6. **Project# 1006703**
13DRB-70606 MINOR - PRELIMINARY/
FINAL PLAT APPROVAL

DRB CASE ACTION LOG - BLUE SHEET

Project Name: SUMMER GARDEN ADDITION

**CITY OF ALBUQUERQUE
PLANNING DEPARTMENT
April 10, 2013
DRB Comments**

# PLAT OF LOTS 1 THROUGH 4 ROSEMONT SUBDIVISION

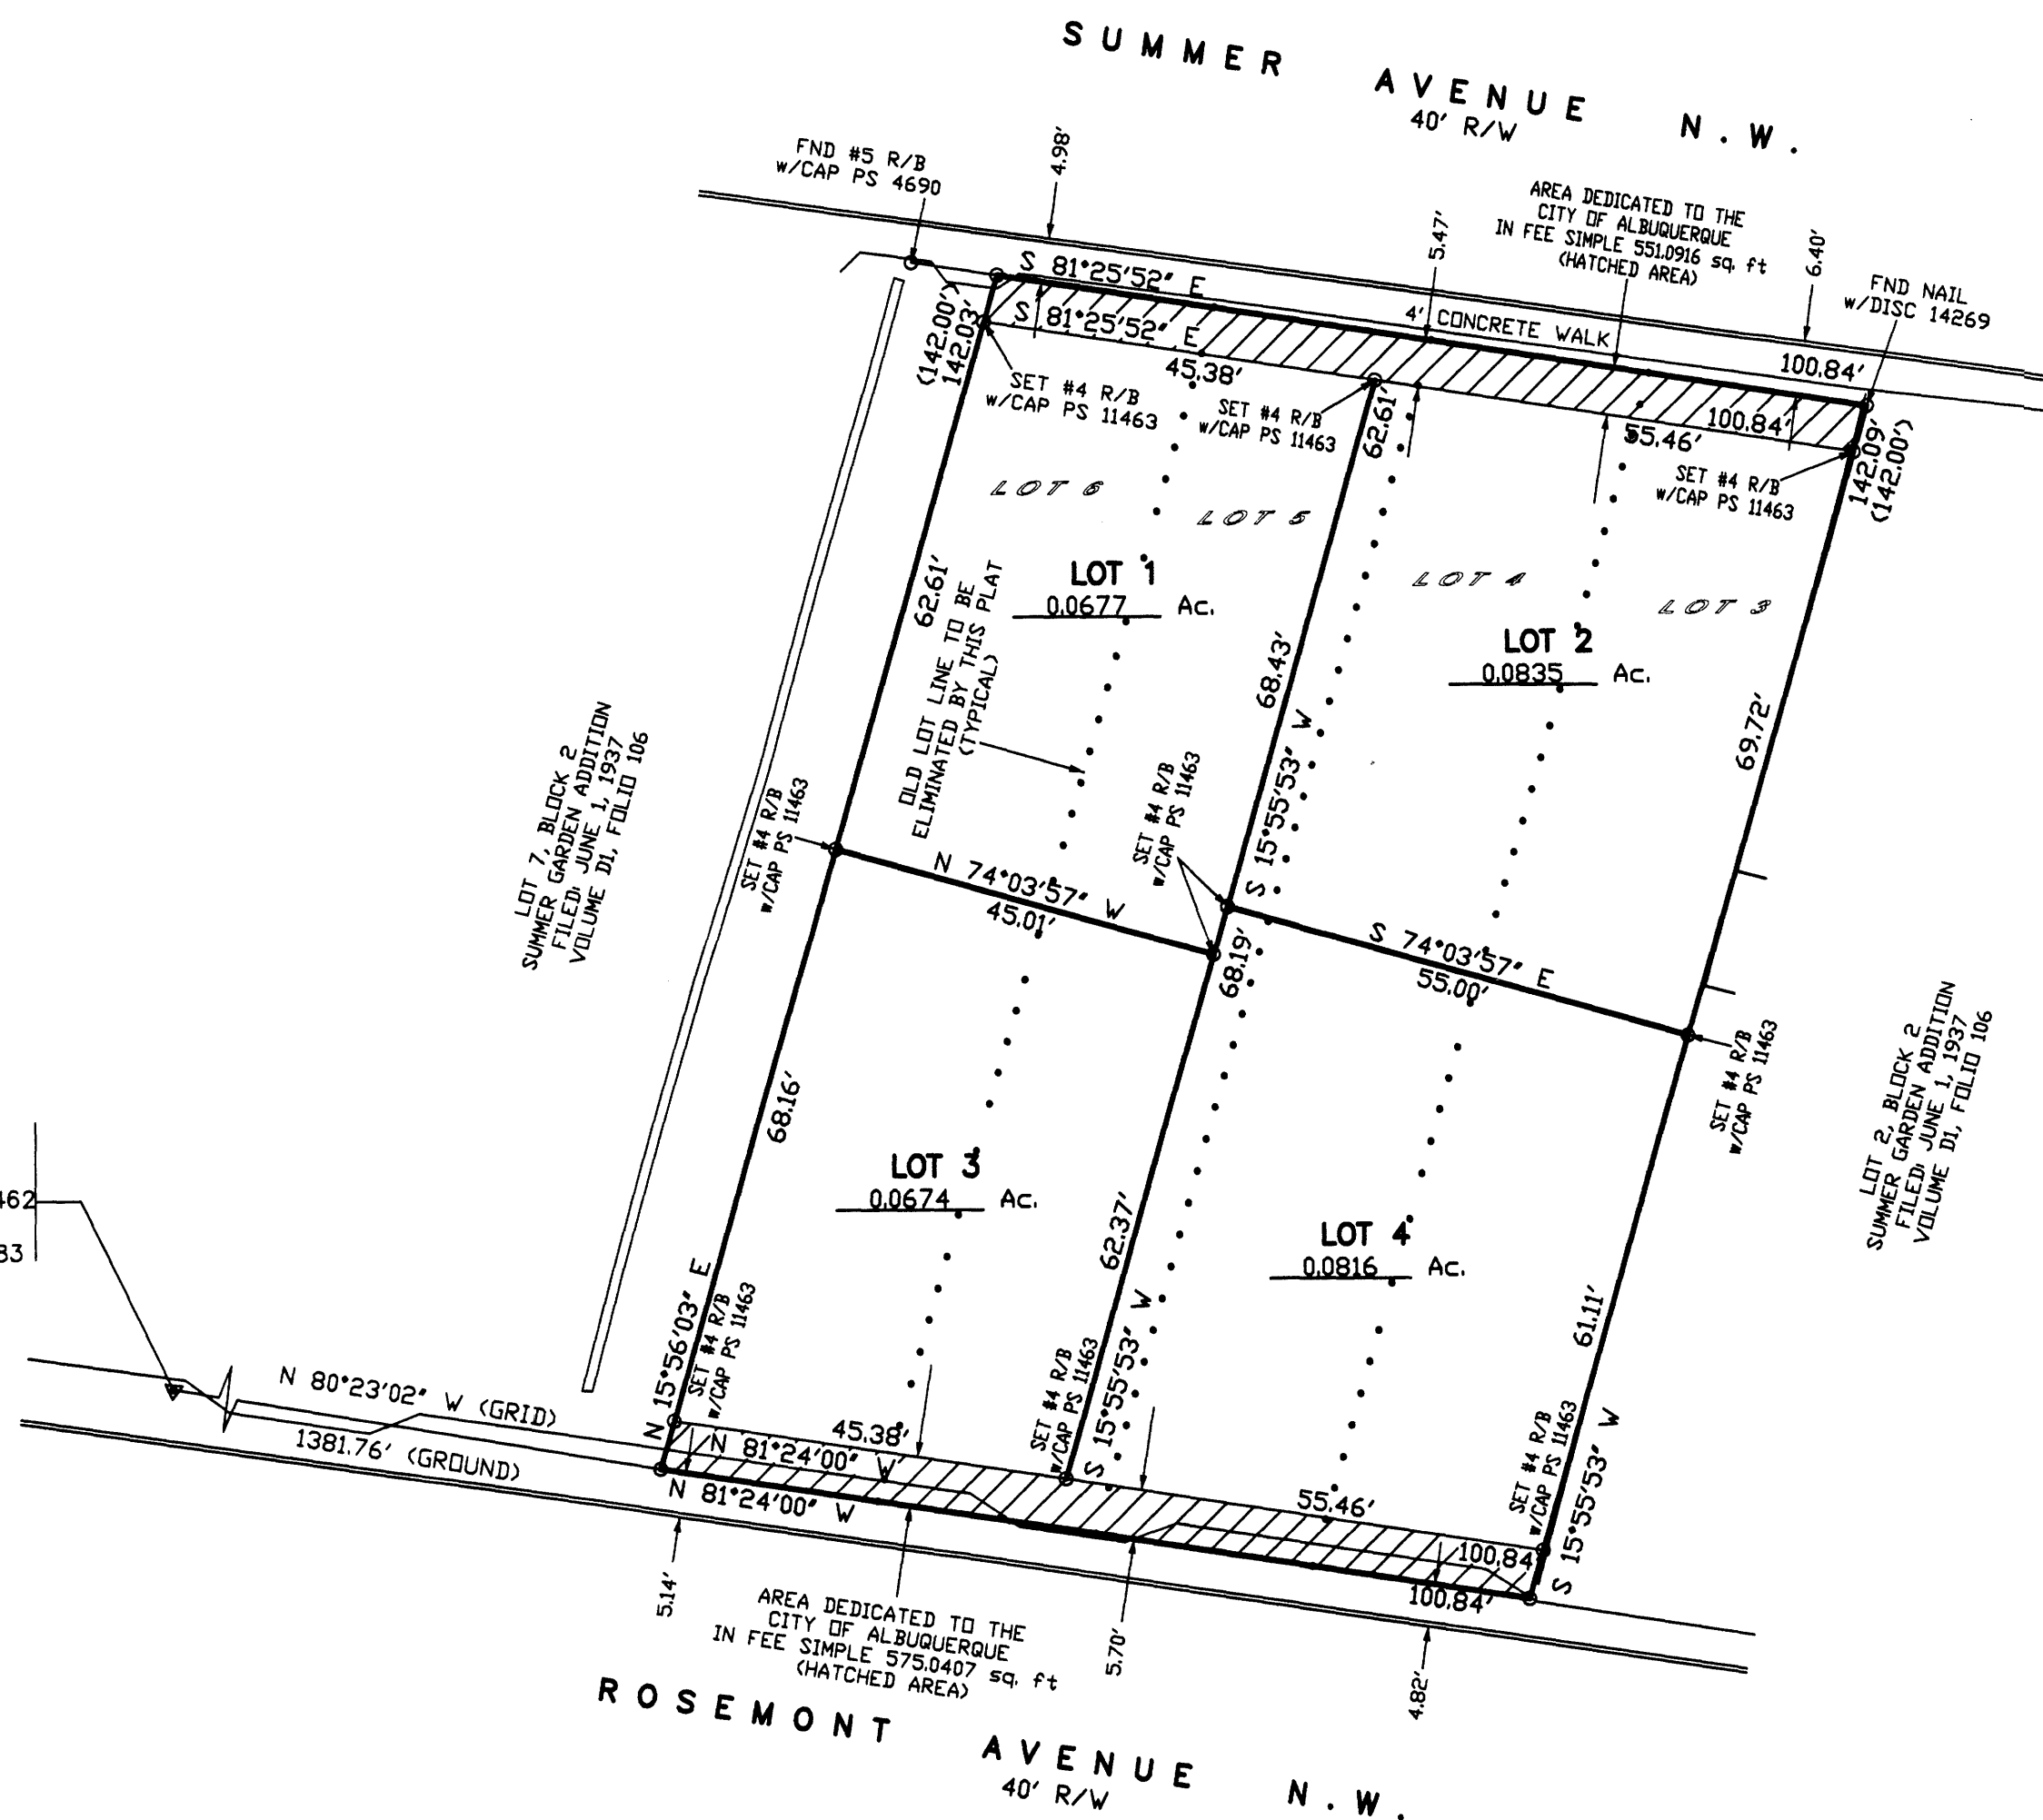
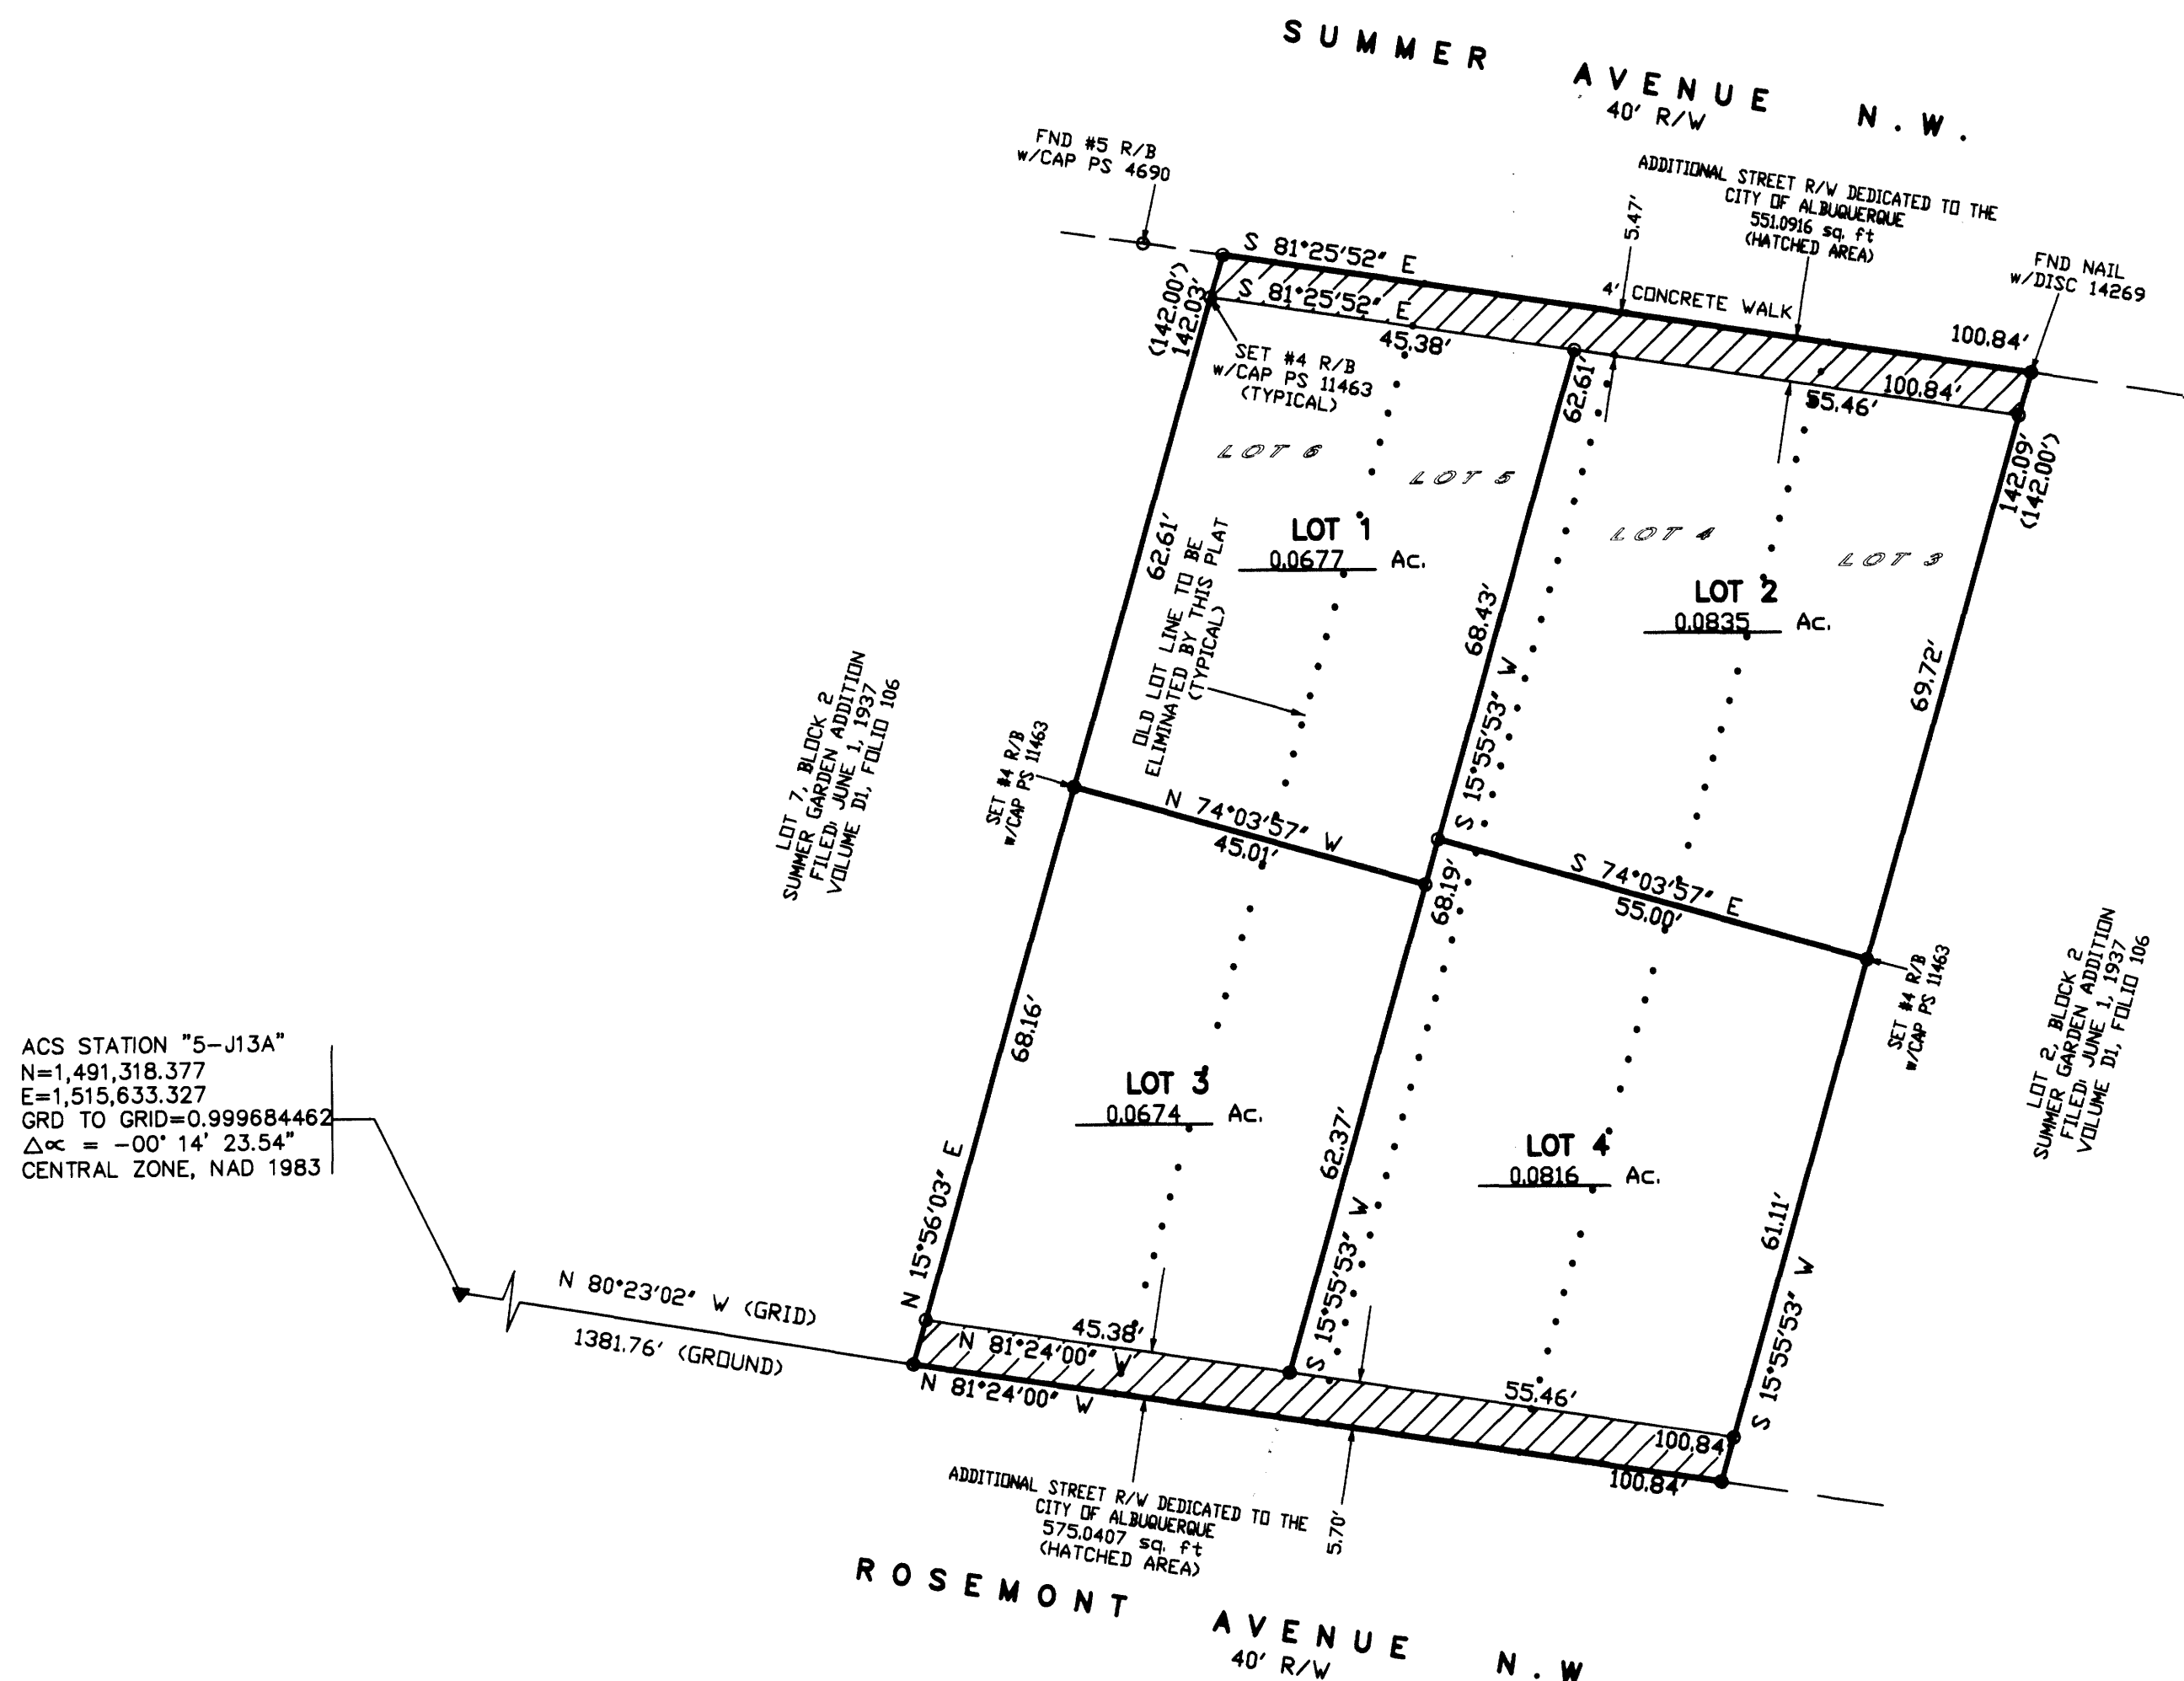
PLANNING (Last to sign): Add note for 1950 Need

ABCWUA Comment: All new lots will require separate water and sewer services.

Provide an exhibit showing the location of sidewalk and defining the distance from face of curb to the property line. Right of way dedication may be required.
Infrastructure may be required.

The site is zoned S-R; minimum lot size for a house is 5,000 sq ft – it appears lot size variances would be required.

'Portions of' Lot 7 would have to be documented by deed dated prior to 1973, or else all of Lot 7 would need to be included in the replat.

A grading and drainage plan is required for preliminary plat approval.
Curb and gutter and sidewalk may be required.

Water harvesting will be required as part of the grading and drainage plan.
